From: Robin Reay [REDACTED]
Sent: 25 September 2017 16:37
To: Simon Davis
Subject: PLANNING APPLICATION REF. Y/40/17/OUT - BONHAMS, HOE LANE, FLANSHAM

Having seen the consultee comments from your Greenspace colleague Sue Howell, can I respond to her comments in terms of the amount and layout of the open space within the proposed development. As we have discussed previously it needs to be born in mind that the application is for outline permission with layout a reserved matter; the submitted layout is therefore indicative rather than final.

BS Calculated root protection areas

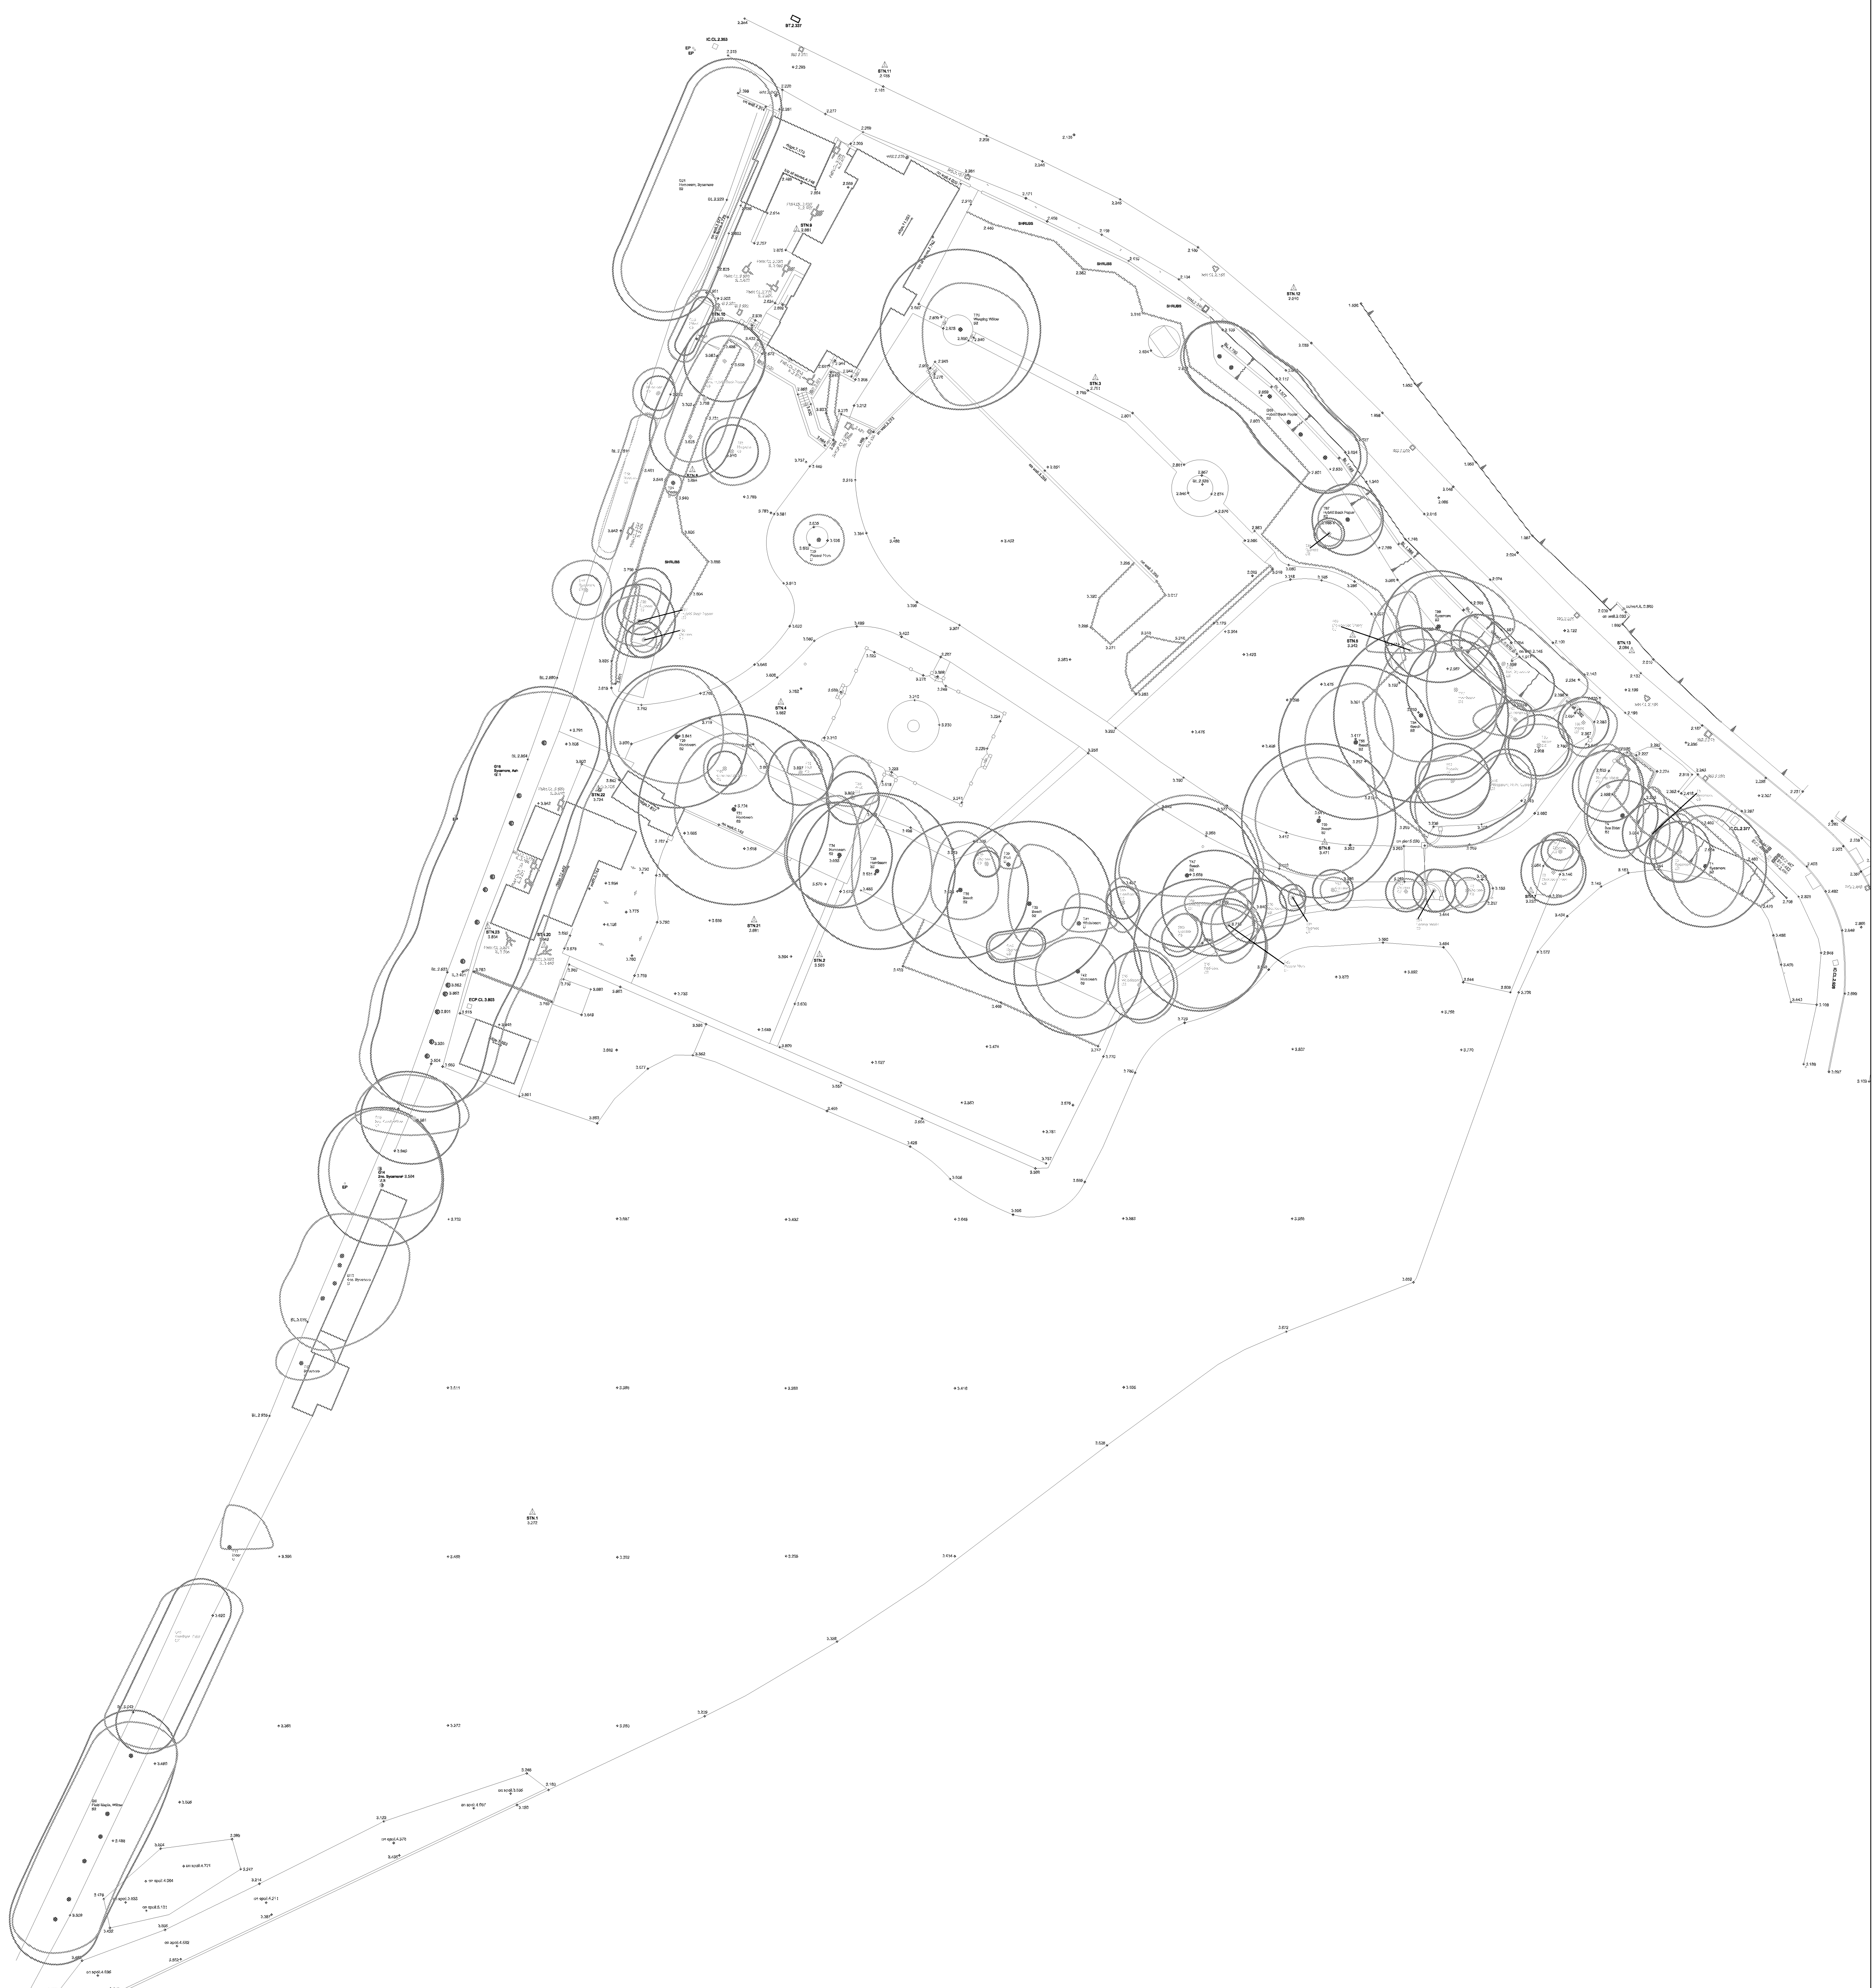
The Greenspace comments also refer to trees within the site. The attached drawing shows the root protection areas for the existing trees to be retained. A report on the inspection of trees and a tree constraints plan were submitted as part of the application documentation and the indicative layout is careful to avoid impinging on the RPAs of existing trees to be retained. There is only one instance where any building impinges on a RPA; that is a very small area for the garage to plot 04, which could be easily resolved by the use of a special foundation for that part of the building.
